Re: Planning Application 18/0435

Address: 32 Hall Street Clitheroe BB7 1HJ

Description: Demolition of existing property and associated outbuildings and erection of six three-bedroomed town houses.

With respect to this application we would not wish to raise any objections. There are however still a number of concerns regarding the development. These can be allayed by way of further submissions prior to planning permission being granted or they can be suitably conditioned. These comments are based on a project plan numbered GRAHA/01 / DWG 01C

| Project No: GRAHA/01 / DWG 01C |   |   |   |  |  |

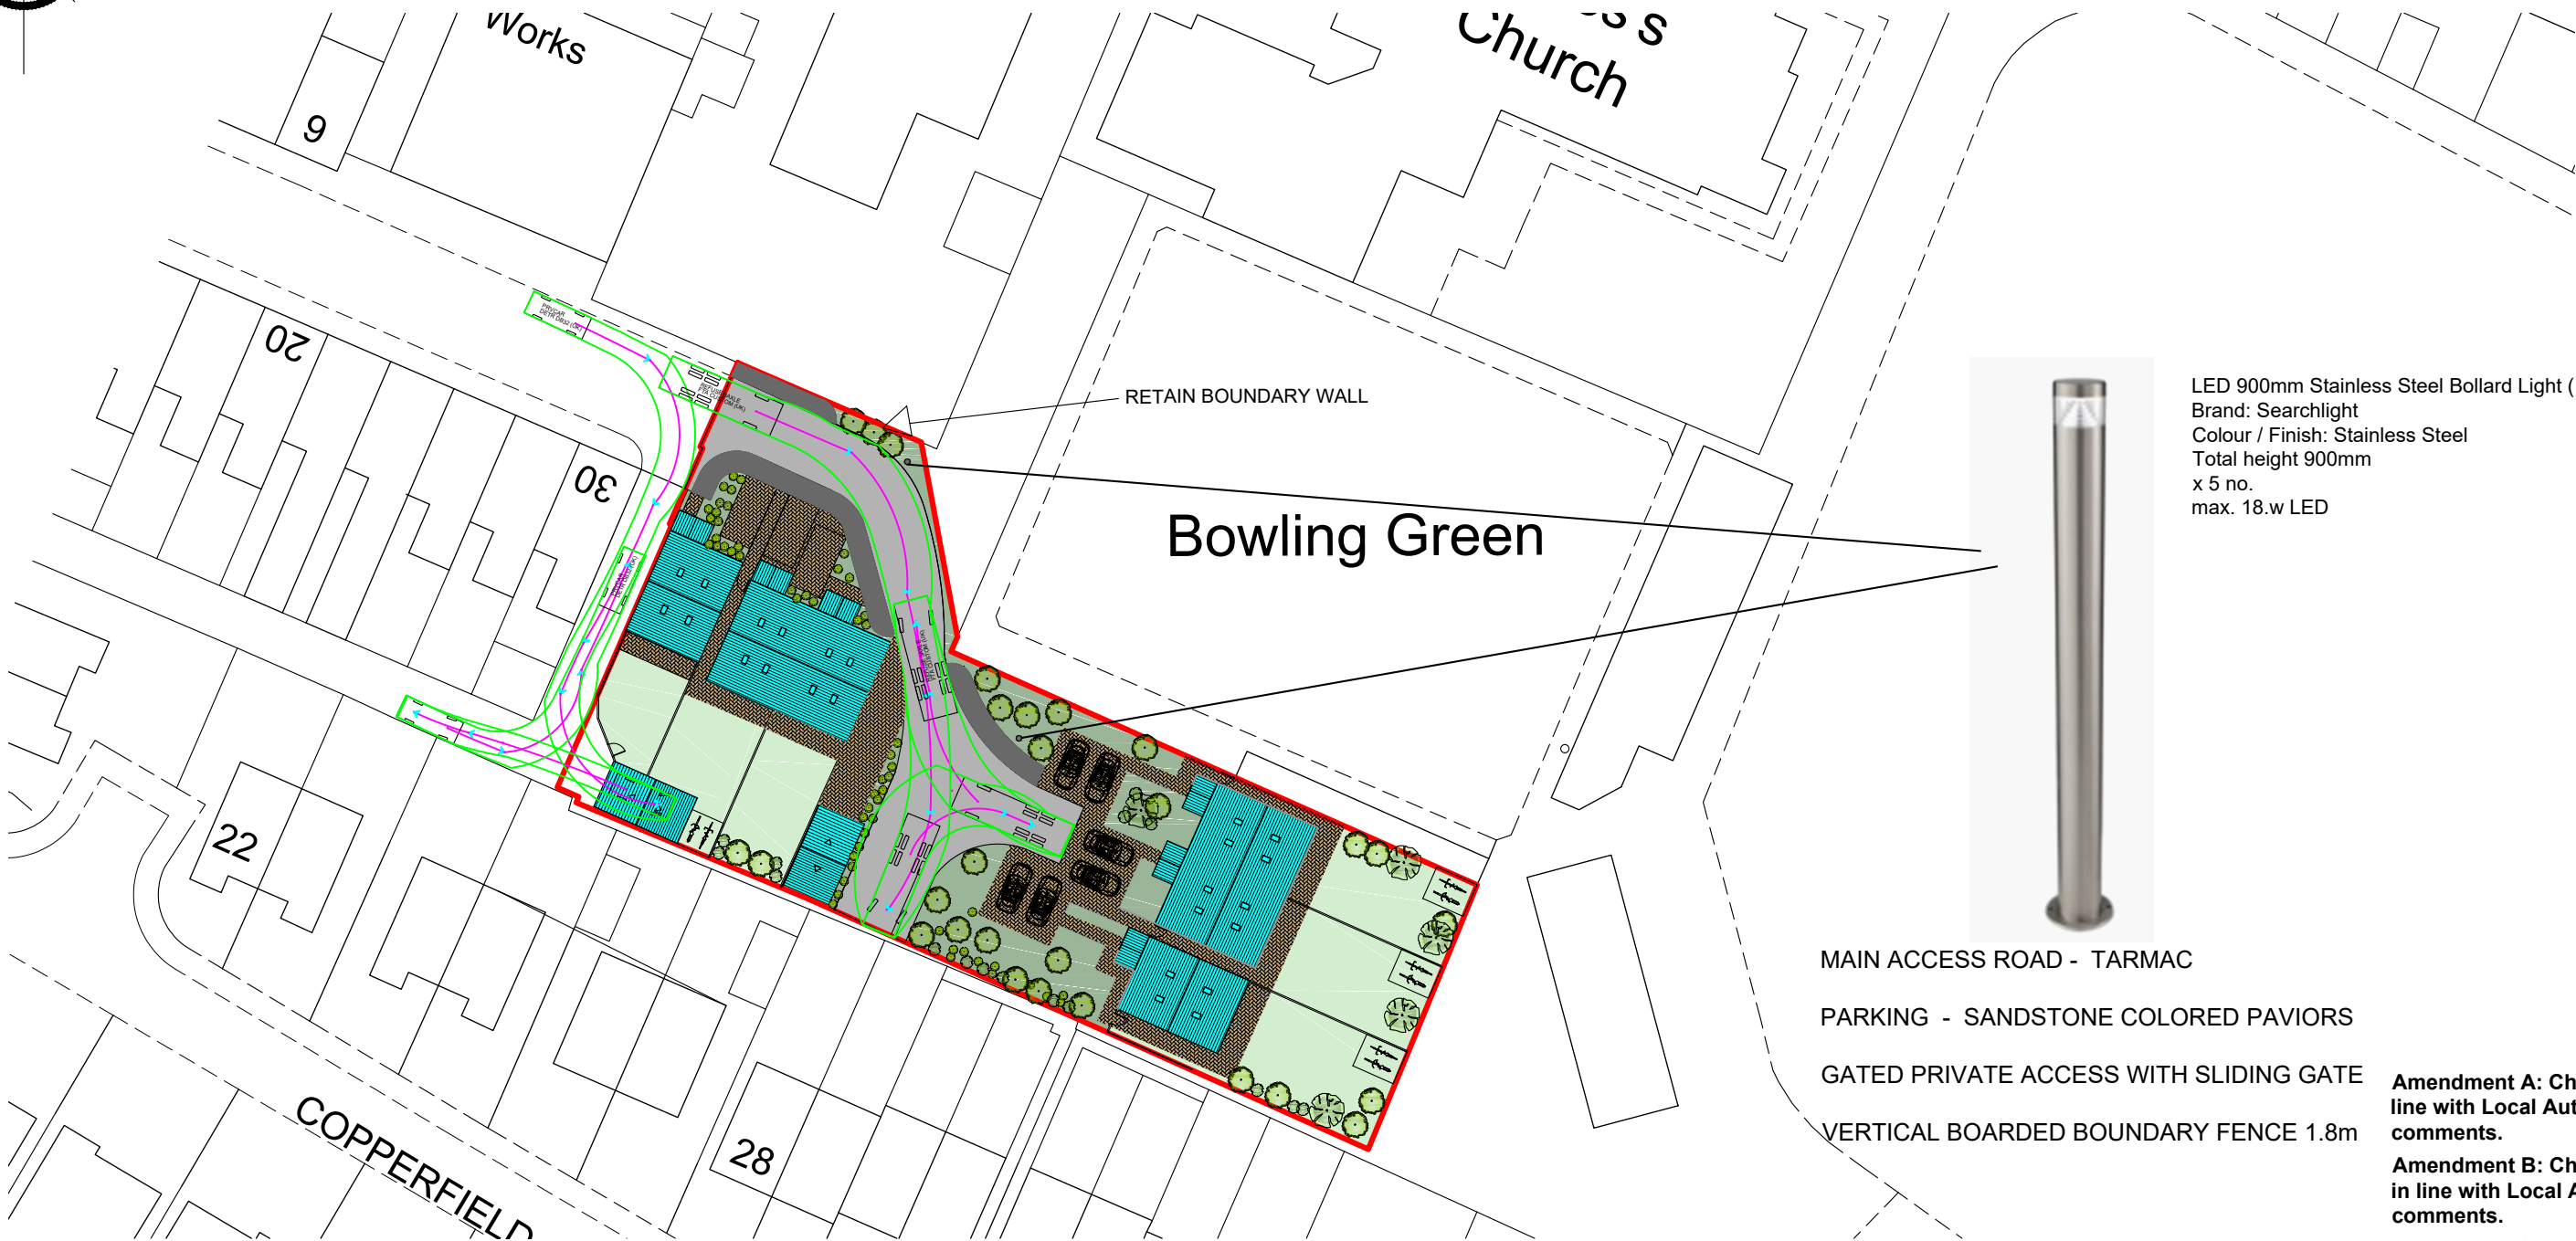
This plan shows alterations to the parking layout at plots 4-6. The alteration raises further concerns regarding the useability of the parking spaces relating to the distance they may have to reverse to either access the space and drive away in a forward gear or enter in a forward gear and then reverse away before turning to exit the development in a forward gear.

- There is a concern that although a garage has been provided to Plot 1, its access will be tricky at best, which is likely to lead to the garage not being used much and the vehicle being parked in the back lane or elsewhere within the new development causing an obstruction
- It may not be possible for the front door of plot 2 to be used if a vehicle is parked filling the space provided.
- Although some street lighting has been shown it is not expected to have achieved any recognised lighting class under BS5489 nor has there been any indication regarding the provision of any surface water drainage.

- The swept path analysis undertaken to ensure that a refuse collection vehicle can enter and exit the development in a forward gear has only been shown in one direction, this may not be the preferred direction by the driver this should be repeated in the other direction.
